DECISION NOTICE

Application Ref: M/35/08/

26 Sea Way
Elmer Sands
Middleton on Sea

Extension and alterations to provide 3 bedrooms, bathroom, ensuite and stairhall.
(Resubmission following M/154/07)

PROPOSED
ELEVATIONS

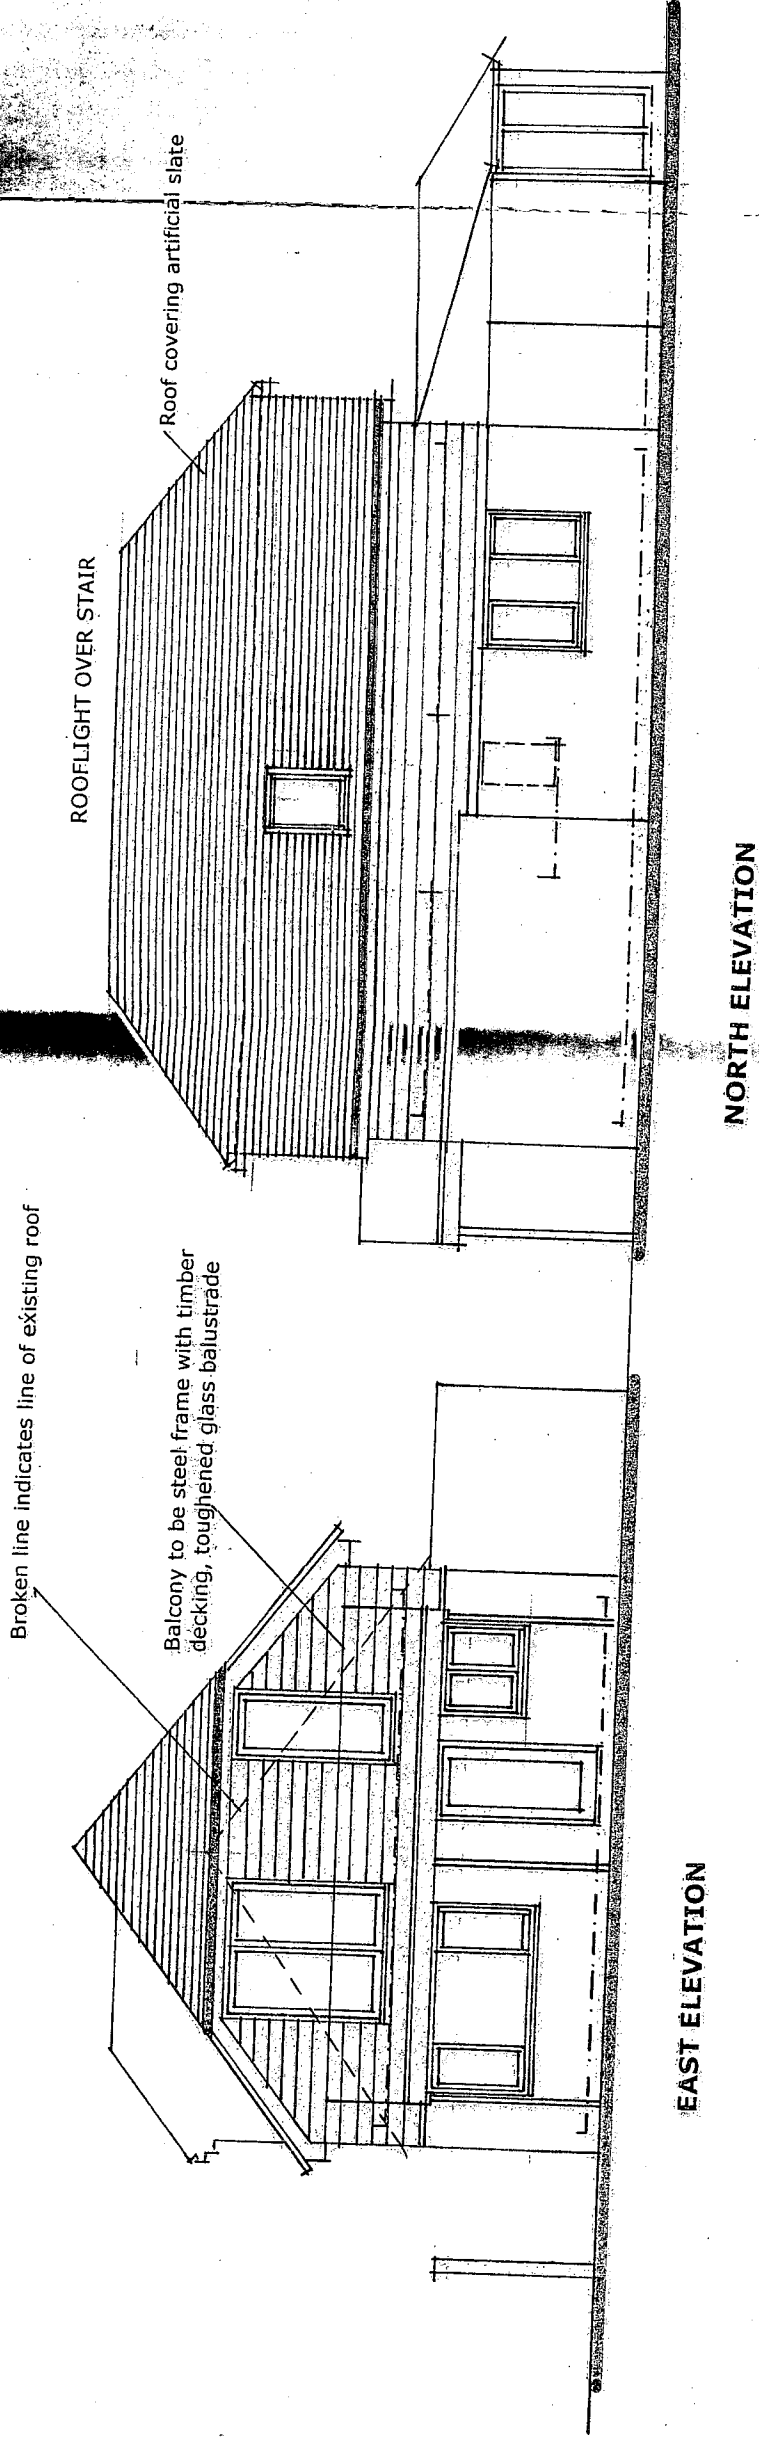
CONDITION 2 The dormer window on the south elevation of the roof extension shall at all times be glazed with obscured glass and shall consist of at least two lights divided horizontally with the bottom light being permanently fixed and only the top light capable of being opened.
